**RE: B&D Industries
9720 Bell Ave SE
Temporary C.O. - Accepted
Engineer's Certification Date: 07/10/20
Engineer's Stamp Date: 10/4/19
Hydrology File: L20D071**

Based solely on the Certification received 07/13/20, this certification is approved in support of Temporary Release of Occupancy by Hydrology. The following comments need to be addressed prior to acceptance for Permanent C.O.

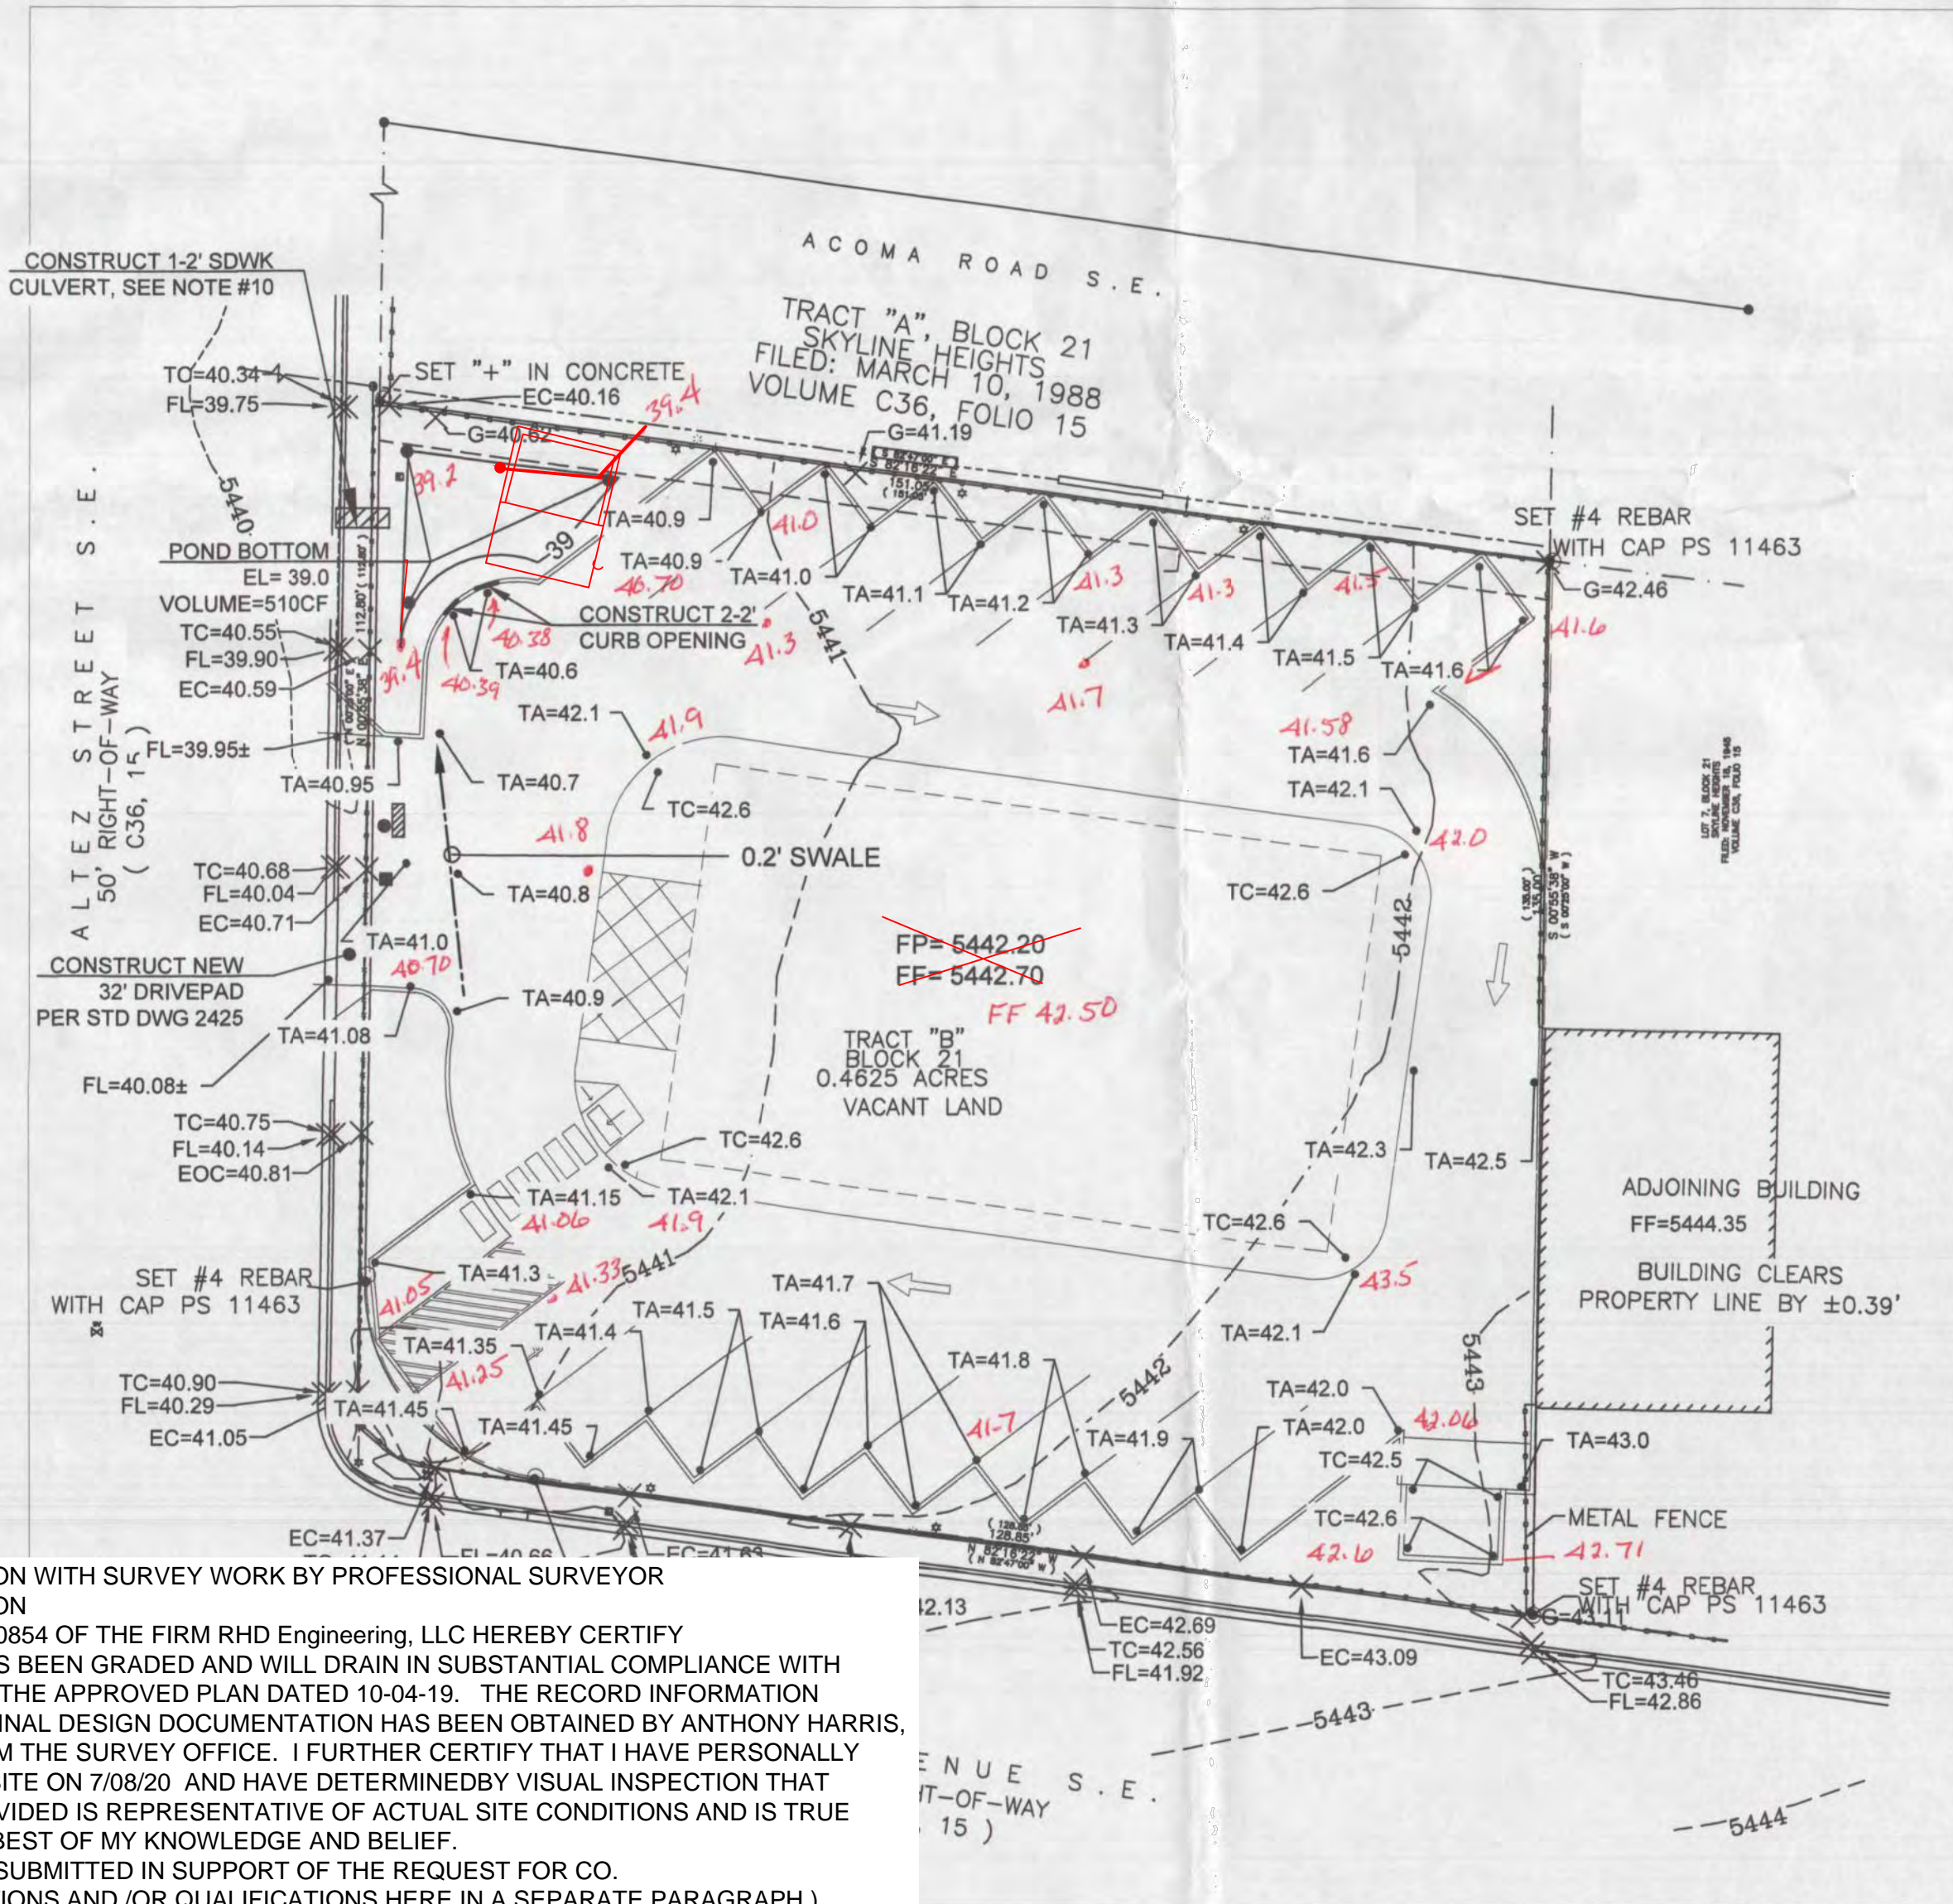
1. The sidewalk culvert must be inspected and approved by Storm Drain Maintenance (Augie Armijo at (505) 857-8607). I have already been in contact with him and I'm waiting for his inspection.
2. There appears to have been parking installed over the stormwater quality pond. This will need to be addressed and the as-built volume needs to be calculated. If the volume is less than what is required, then a payment-in-lieu will need to be paid.
